STATE OF NORTH CAROLINA  
DEPARTMENT OF TRANSPORTATION

SUBJECT: Project 34472.3.2 (R-2582A) Northampton County  
US 158 / NC 46 from I-95 / NC 46 in Roanoke Rapids to  
SR 1312 (St. John Church Road)

**Construction Revision for eSigned Projects**

18-AUG-2020 12:24 R-2582A-EC-19A-CONST.19-PIPE CONSTRUCTION SEQUENCE.psh_19A.dgn

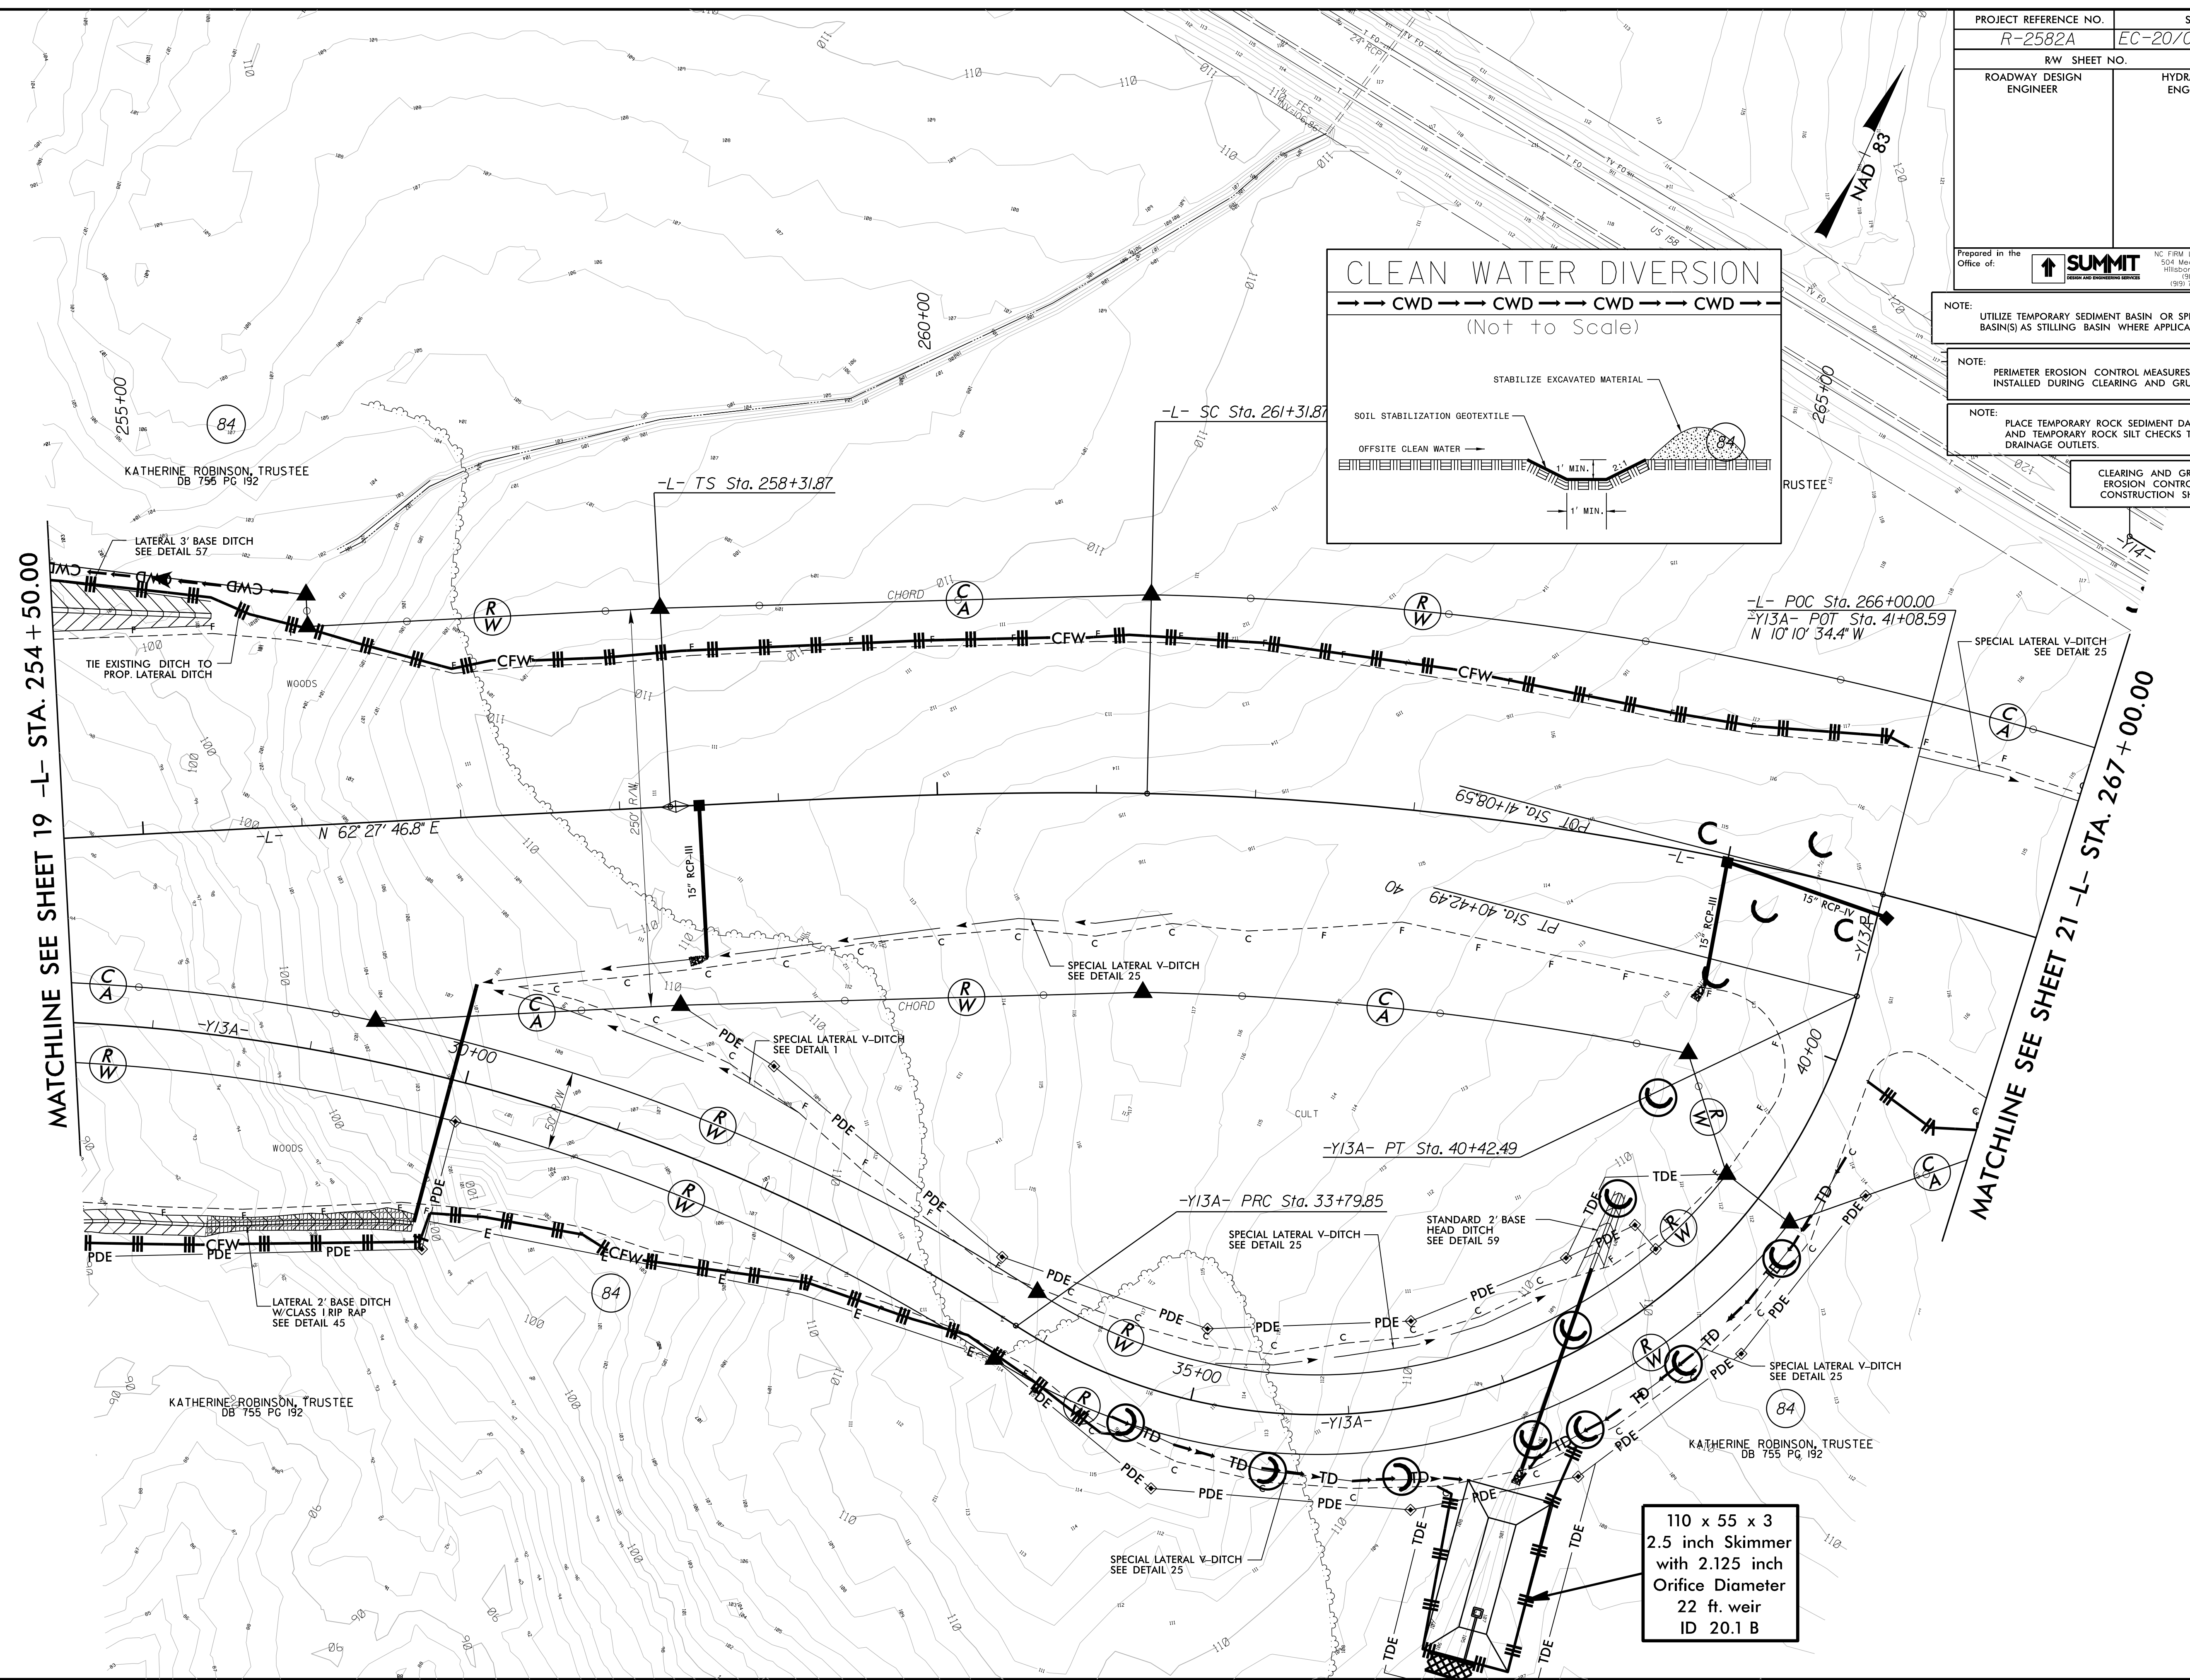
EC-19A

- Re-printed sheet to show basin that was already accounted for in design and quantities. The sheet had been previously reviewed and approved including the basin.
